From: Colm McKee [REDACTED]
Sent: 09 February 2022 13:49
To: Neil Crowther <Neil.Crowther@arun.gov.uk>
Cc: Holly Ross [REDACTED] Ali Salvage [REDACTED]
Subject: Re: Planning Decision on FG/196/21/HH : 9 Telgarth Road

09.02.2022

A :: Proposed West Elevation
02 scale: 1:100

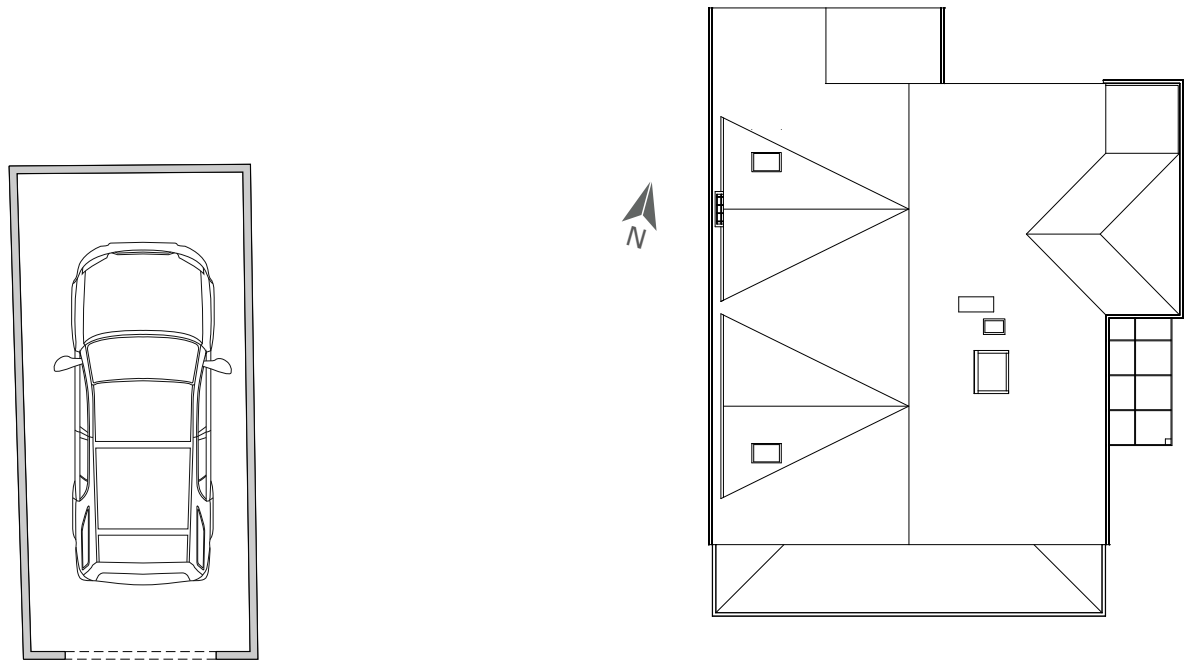
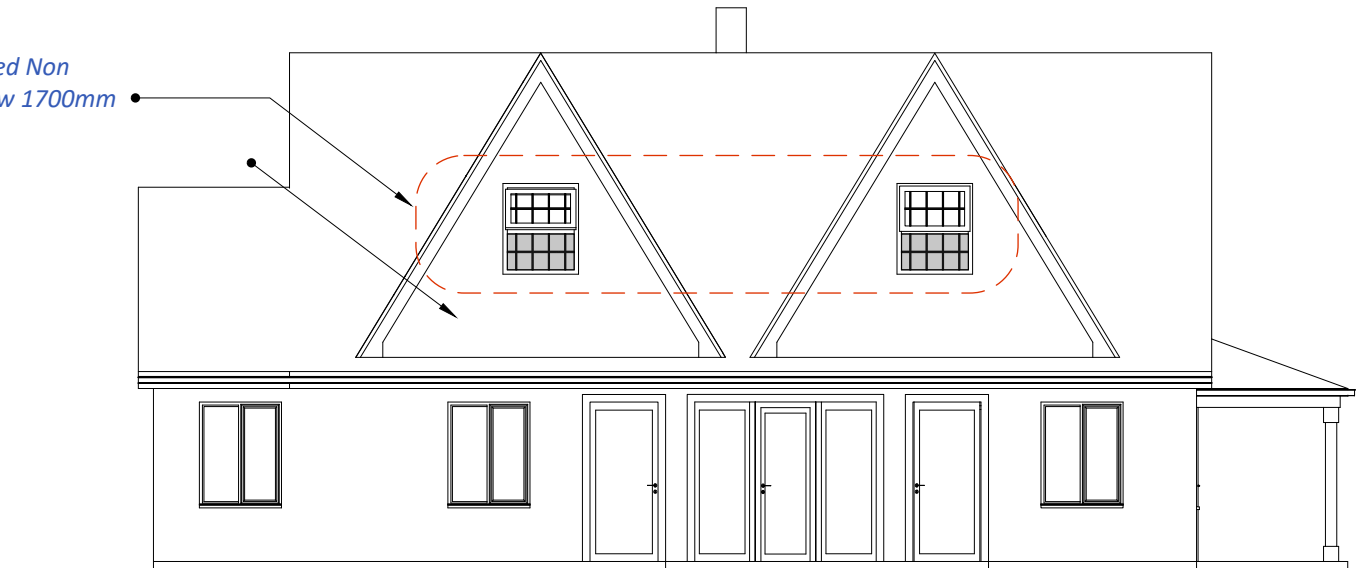
The changes to the roof profile on the front elevation could not be carried out as permitted development. Therefore the large dormer window on the right on the western elevation would not be permitted development. The Council does not have a fallback position for this element of the proposals. The rearmost dormer window was comparable to what was approved under FG/151. However, as they are contained within an overall proposal that requires planning permission it is not the case that this element can be considered in isolation. Further, the side facing dormers are of a significantly greater scale than those within FG/151.

The Inspectors comments on the quality of the living environment as a result of such windows is also material. The decision would still have been to refuse due to unacceptable overlooking. Merely because a window is obscure glazed may not mean that such a window would not result in the significant perception of overlooking if there is activity/lighting etc. behind such windows.

I note the comments re the front elevation - but there has never been an issue with this. Regarding the suggestion there is no fall back for the dormer to the right of the west elevation – both the 'fall back' and the recently refused scheme would serve two individual habitable rooms – both with windows on the west elevation.

Both schemes = 2 obscure windows, both on the west elevation, (except the fall back has over 100% more glazed area).

2 windows @ 1.7m sq each = 3.4 sq m of window on west elevation.

Two windows at 0.77m sq each = 1.54 sq m of window on west elevation.

Fall back windows are 2.2 times larger than the refused windows. Therefore, any 'perceived' overlooking is significantly less as a result of the refused scheme – not the fall back.
